M42 J6 Scheme Improvement TR010027
20022337 Natural England ExAs Third Written Questions – Deadline 6

Date: 10 October 2019
Our ref: 295000 ExA 3 Natural England 101019 final
Your ref: TR010027 Deadline 6 Natural England

Application by Highways England for an Order Granting Development Consent for the M42 Junction 6 Improvement
The Examining Authority's written questions and requests for information (ExQ3) - Issued on 23 September 2019

Annex A - Report 8.55 Soils Survey Report: Soil suitability assessment for ancient woodland and grassland translocation

Map title:
 Map 3
 Soil resources

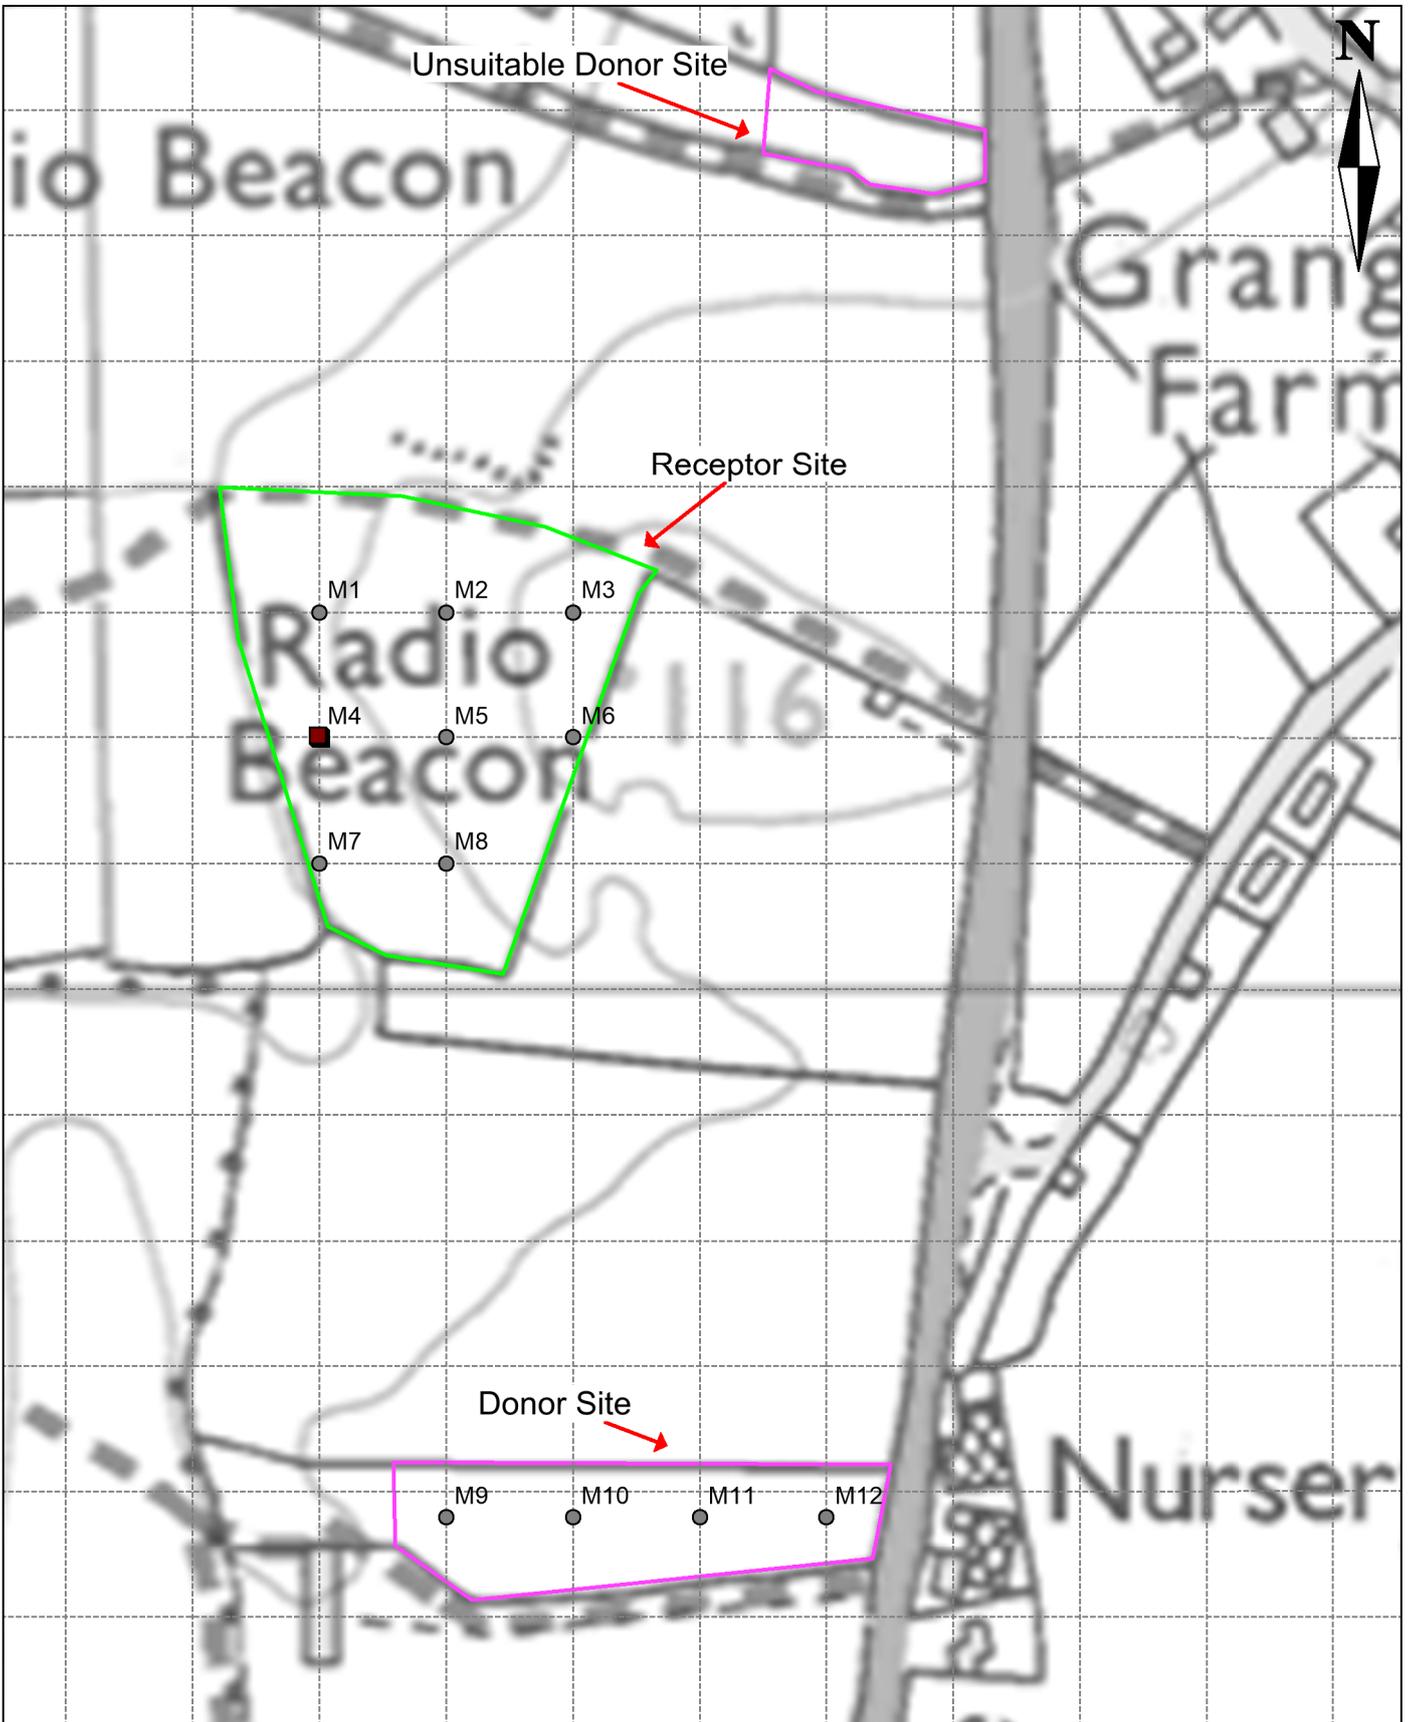
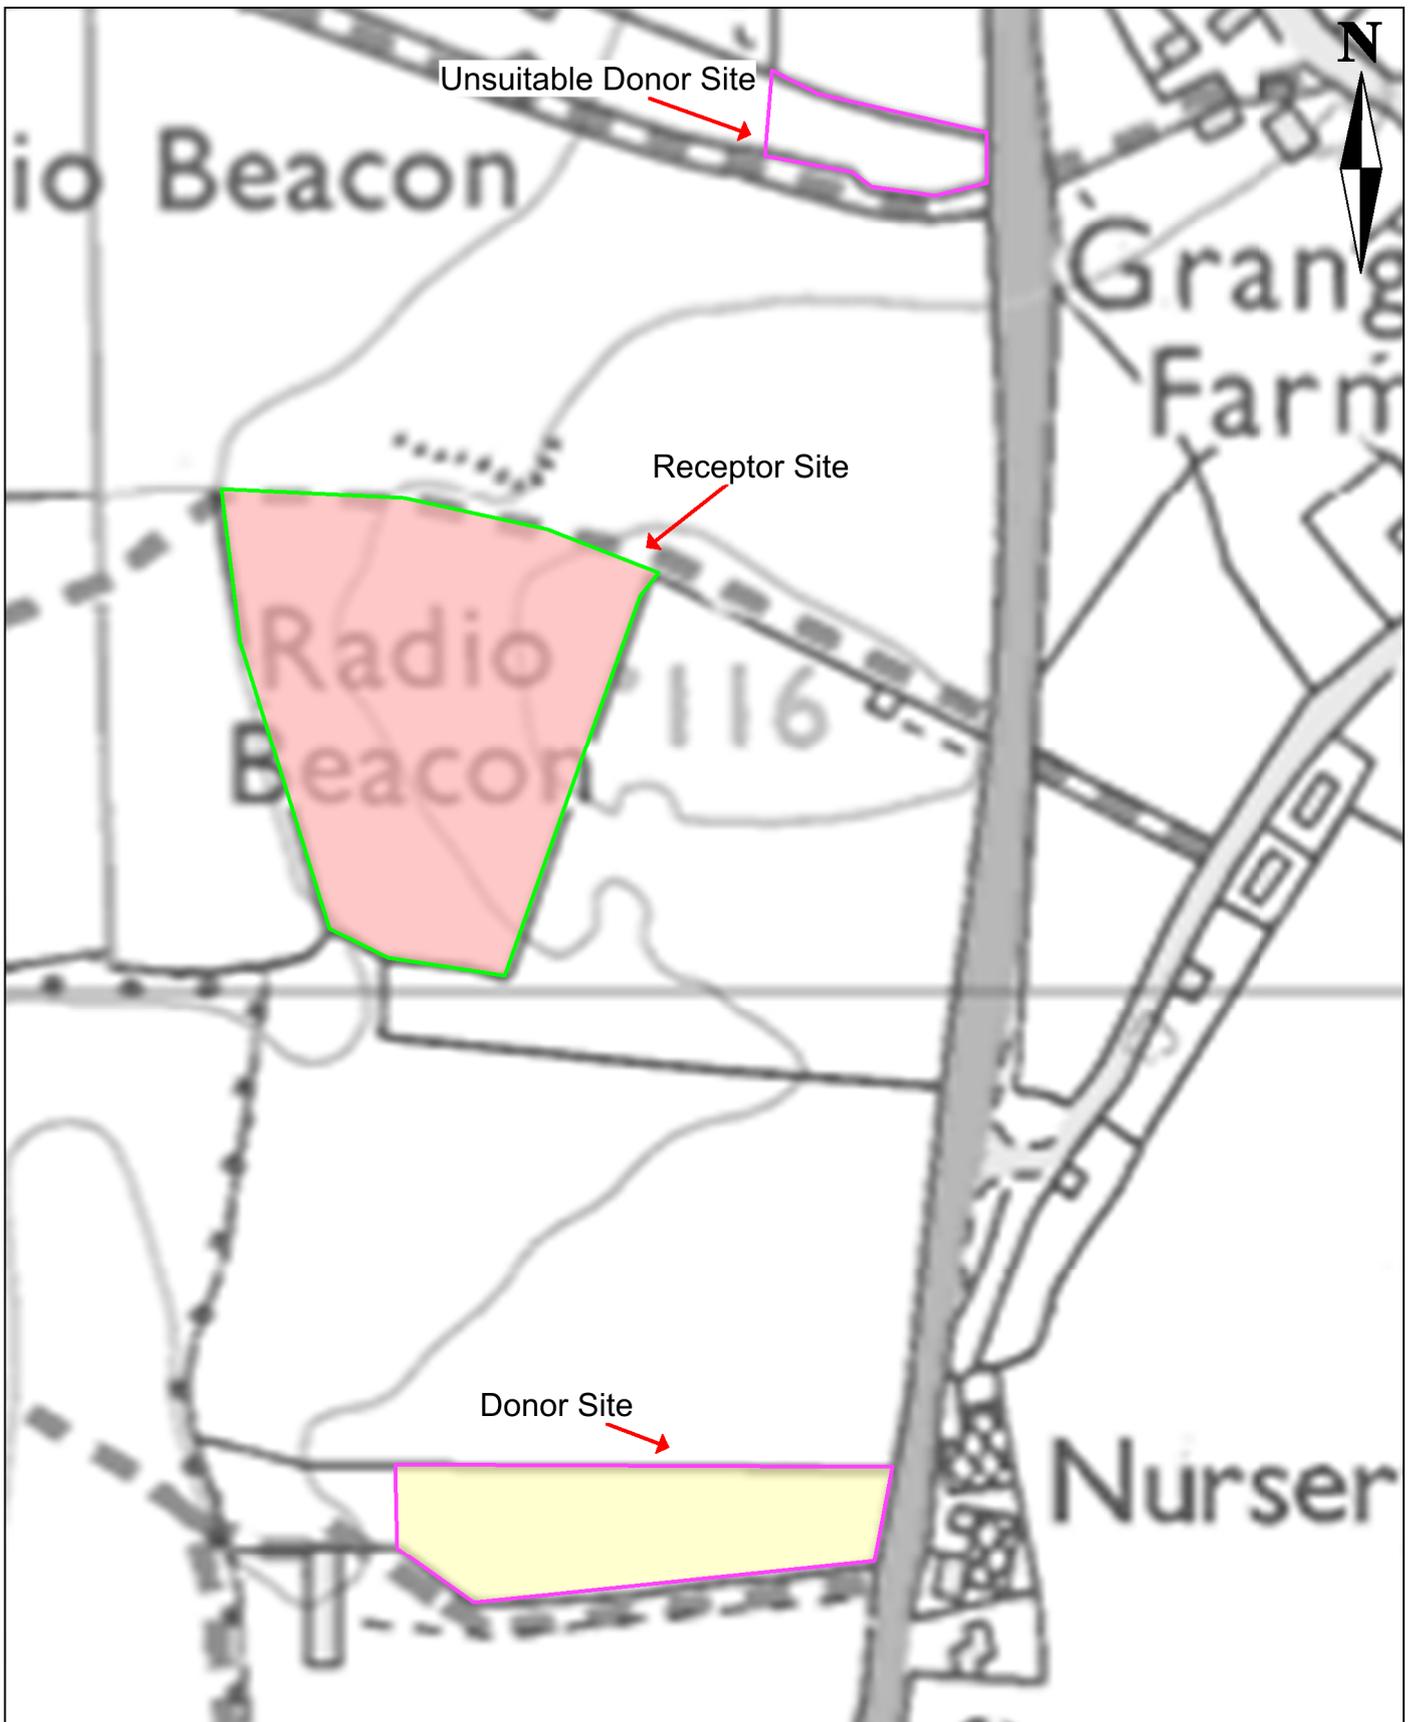
The survey findings indicate that both donor and receptor soils are broadly similar in characteristics, both being poorly draining clay loams. In terms of soil nutrients the donor soils are slightly acidic, with Donor site 1 (east of the M42) having low nutrient topsoil, and Donor site 2 (west of the M42) having moderately fertile topsoil. Subsoils from both donor sites are of neutral pH with low available nutrients.

Receptor site topsoil is neutral with high nutrient levels (Phosphate index 4); subsoil has low available nutrients (Phosphate index 0). The report concludes that the soils are moderately suited to translocation, and goes on to make recommendations on translocation methodology. Natural England supports this view and the recommendations and wish to highlight the importance of:

- Soil stripping the nutrient-rich topsoil of the receptor site prior to soil translocation to minimise potential for a weed burden.
- Not working or tracking on soils when wet / plastic to minimise compaction risk.

- Not translocating subsoils to minimise risk of soil structural breakdown.
- Cultivation of receptor site to alleviate any compaction and facilitate tree root penetration.

- Use of the loose tipping technique to avoid trafficking on the restored surface.
Natural England would normally advise laying soil profiles intact, as cited in the report, however, the high risk of compaction damage to the soils in question is such that we agree with the recommended methodology.

- Move material when trees are dormant in the autumn / winter.
- That coppice stools, saplings and deadwood are all translocated.
- Tree-pit planting for heavier standards.
It would be useful to know what the recommended suitable permeable backfill material will consist of.

Natural England are pleased to see that the surveyed soil receptor site is considerably larger than that originally proposed, and understand that this is in line with recent commitments to further explore expansion of compensatory woodland habitat. Natural England would like to re-emphasize the importance of securing compensatory habitat contiguous with the western half of Aspbury's Copse. Natural England look forward to further constructive discussions on compensatory habitat creation and restoration.
